File No: R/2015/21/C  
Your Ref: SSD 7080

**RE: Proposed mixed use residential and retail development at 80-88 Regent Street, Redfern (SSD 7080) – Revised Response to Submissions (RTS)**

## Attachment A: Review of Response to Council Submission

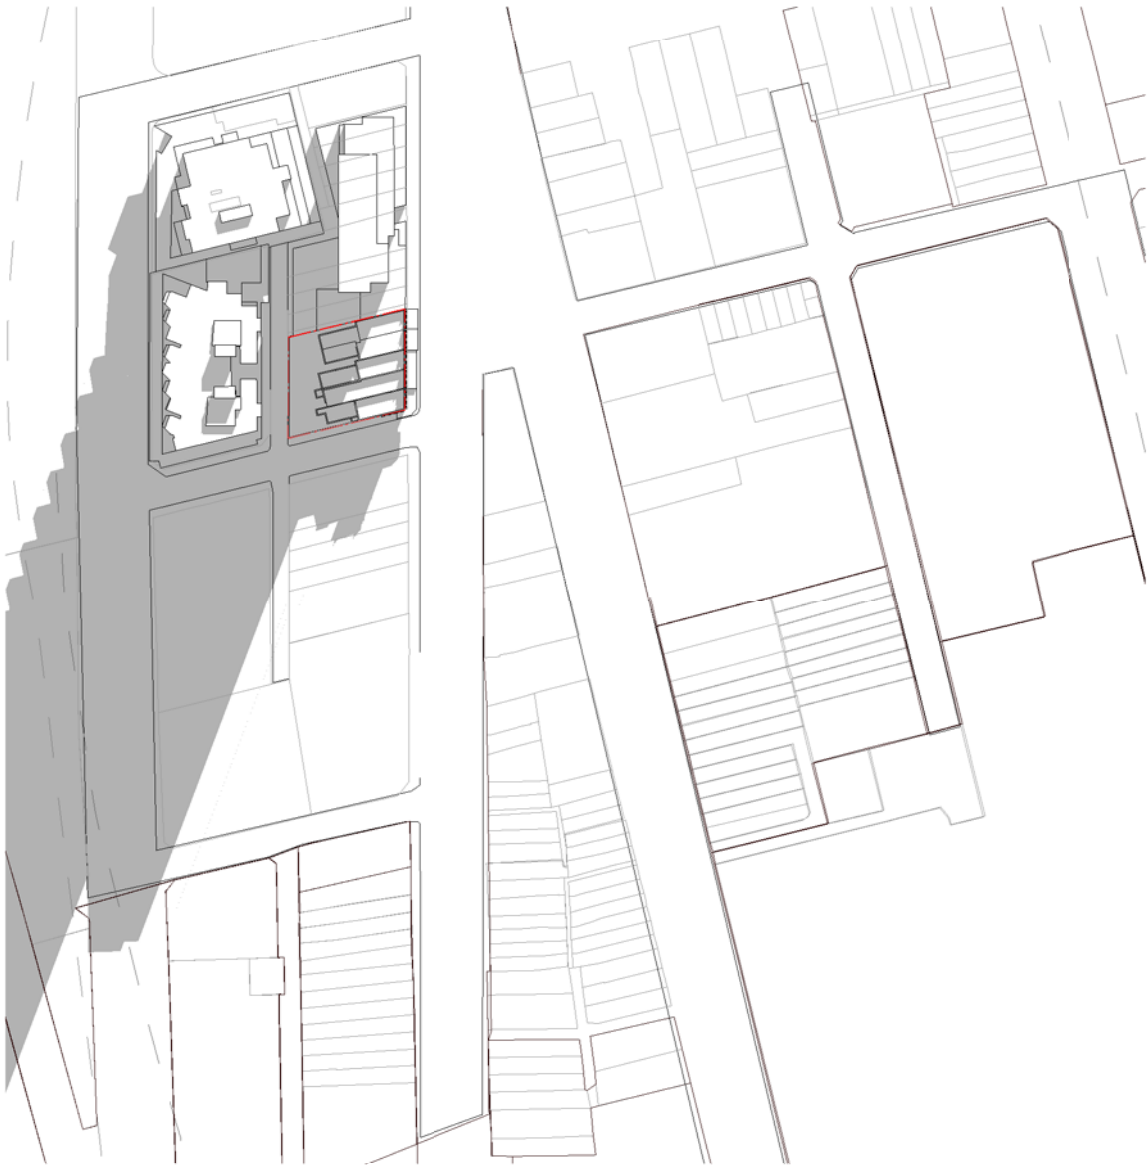
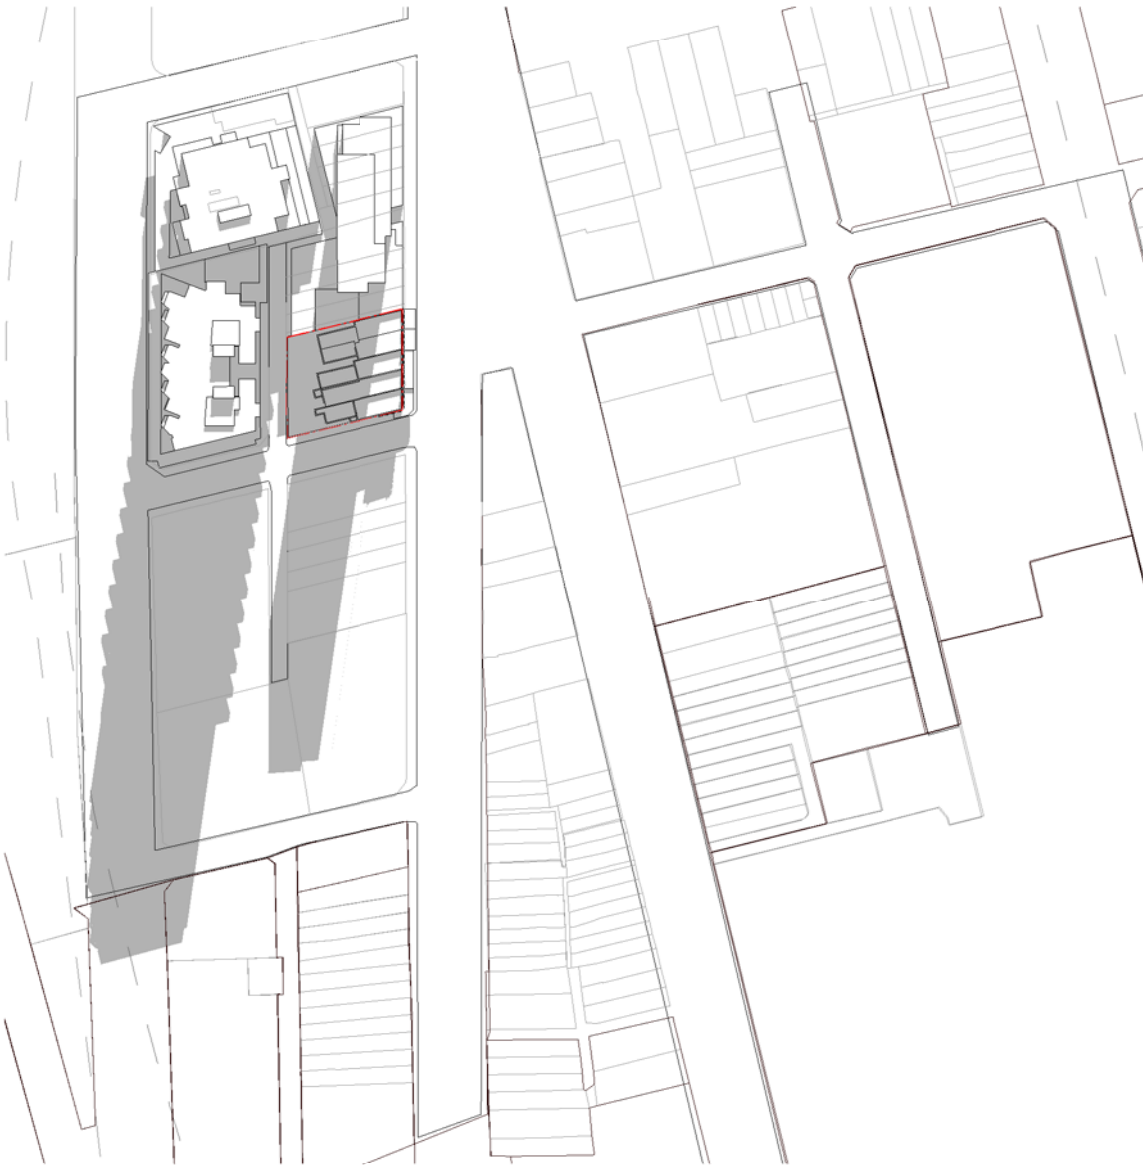
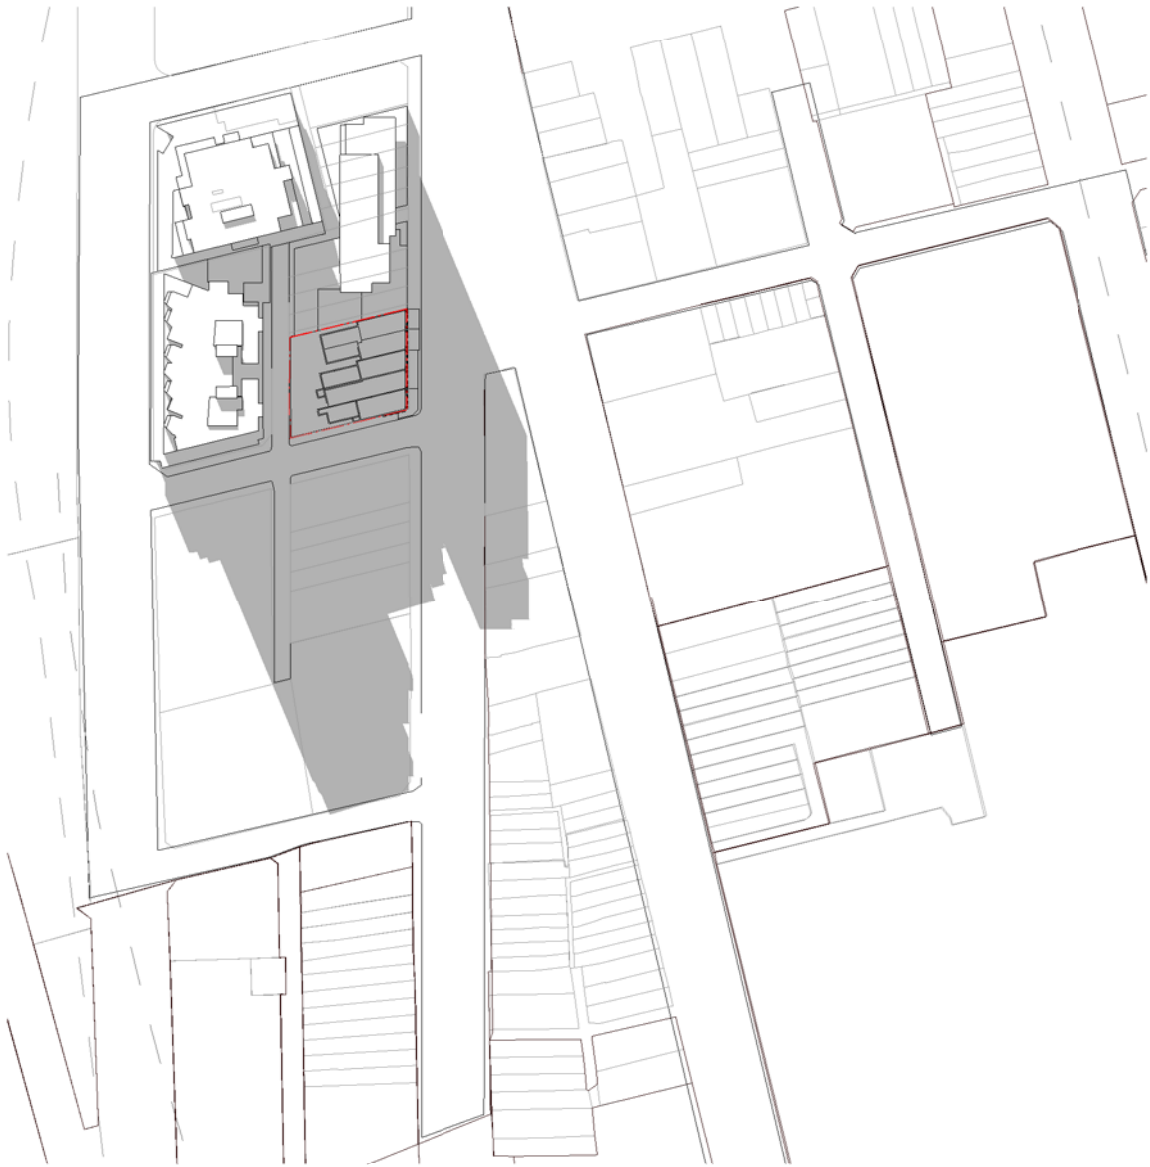
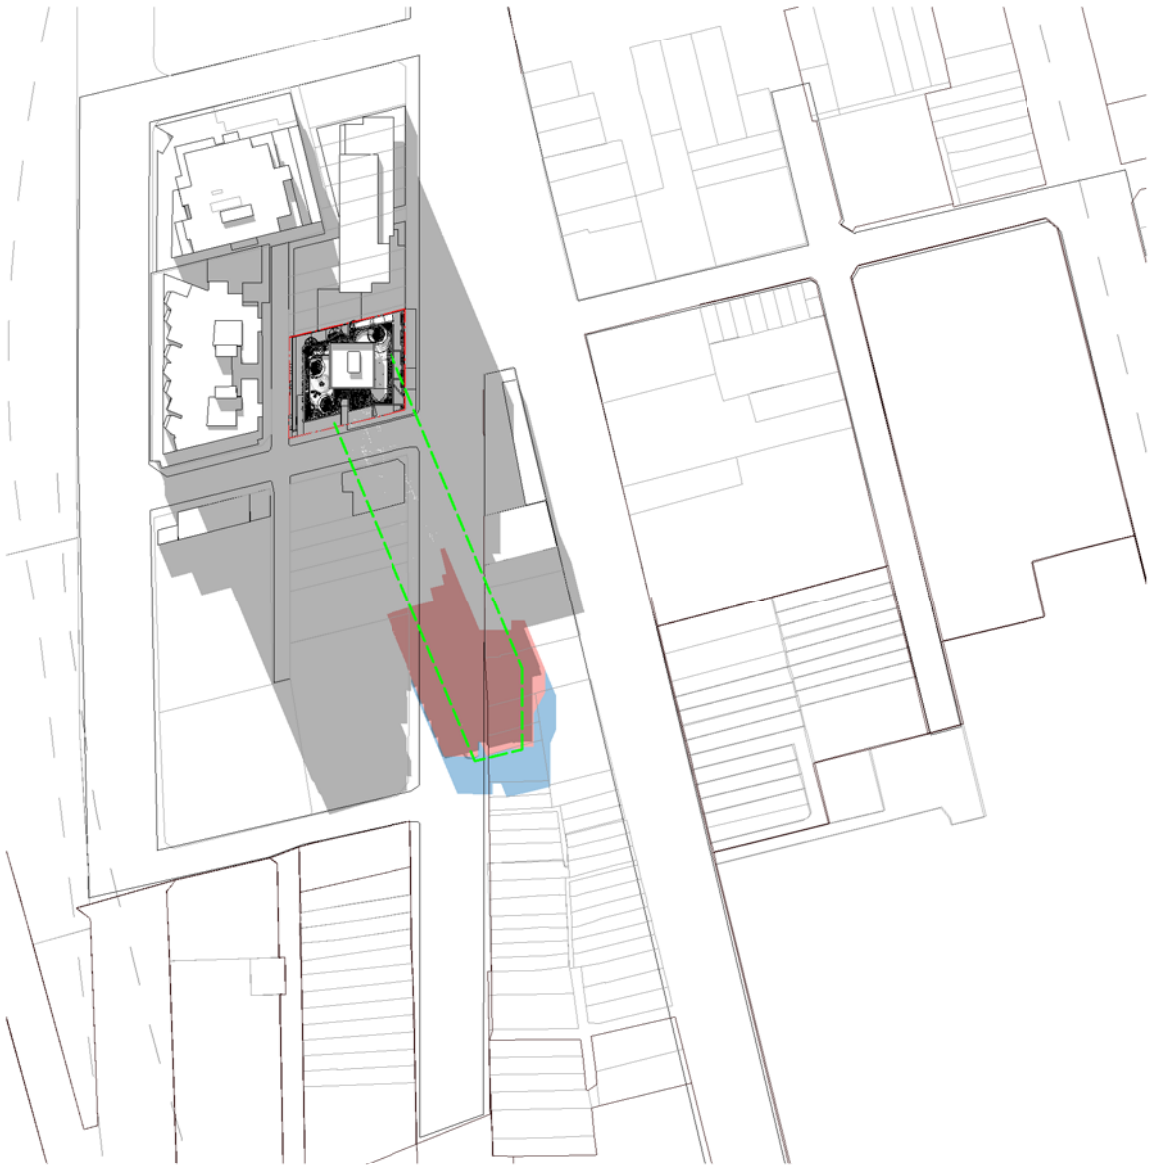
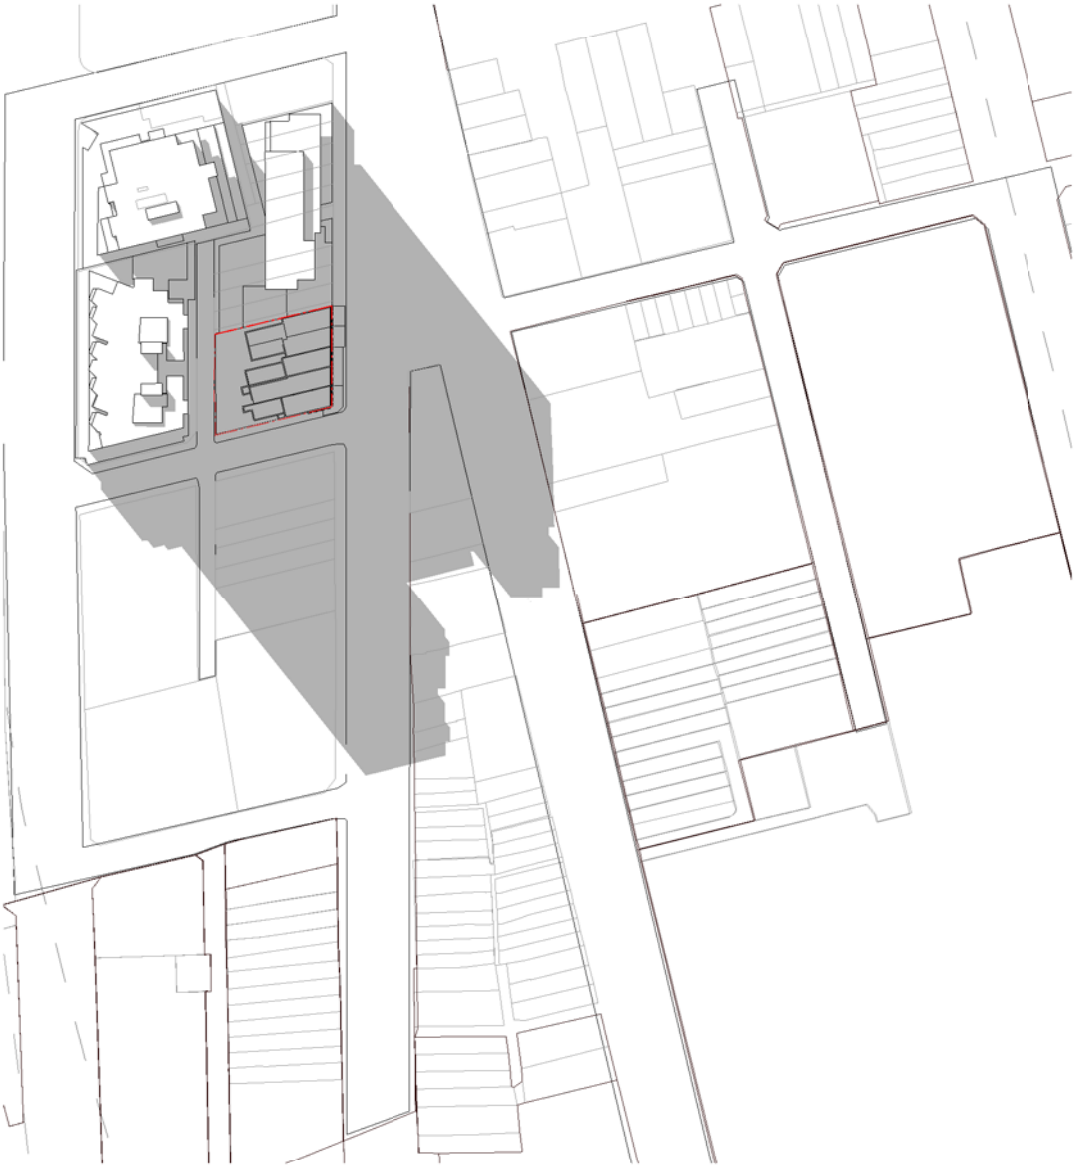
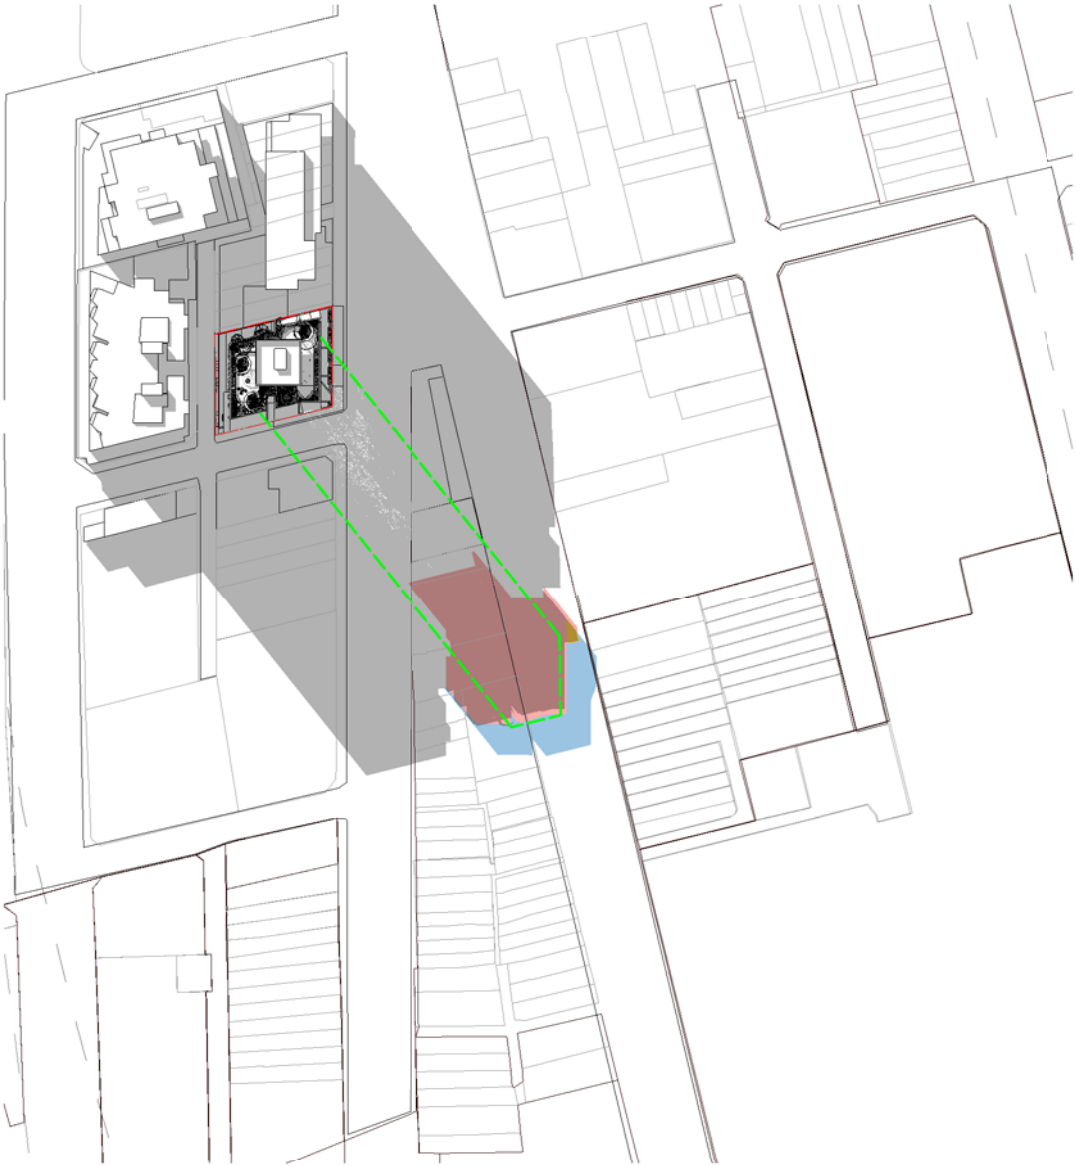
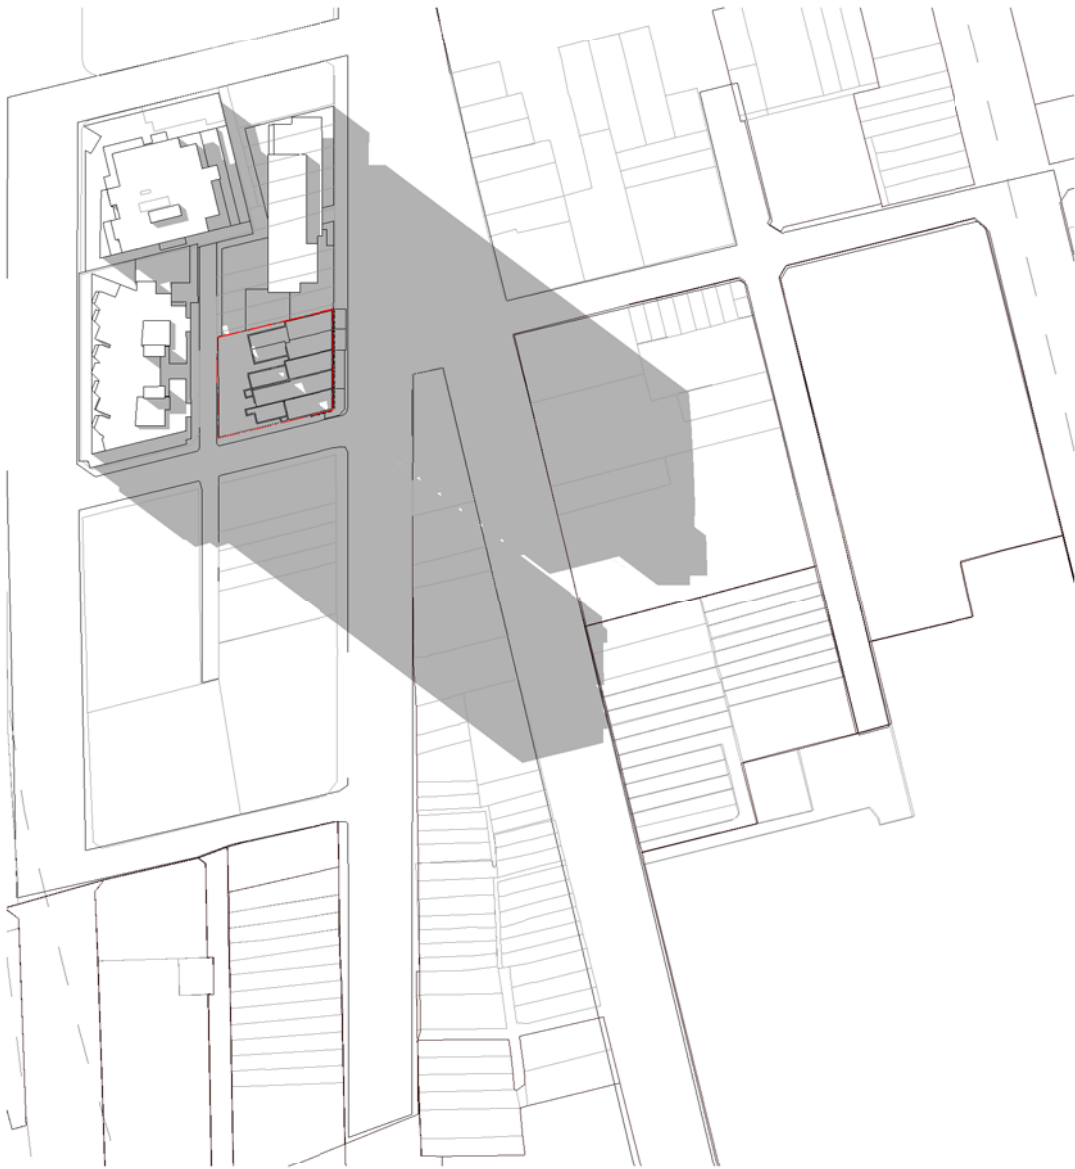
- The shadow diagrams are unclear in demonstrating the extent of the shadow cast by the current proposal. In order to understand the impacts arising from the revised building envelope, a shadow diagram illustrating a compliant 8-storey scheme and the proposed 18-storey proposal should be prepared.

- It appears the proposal will overshadow residential apartments at 1 Margaret Street and the adjacent Gibbons Street Park. A detailed shadow diagram should be prepared illustrating the shadows cast on winter solstice for both sites, in addition to elevational shadow diagrams for residential apartments.
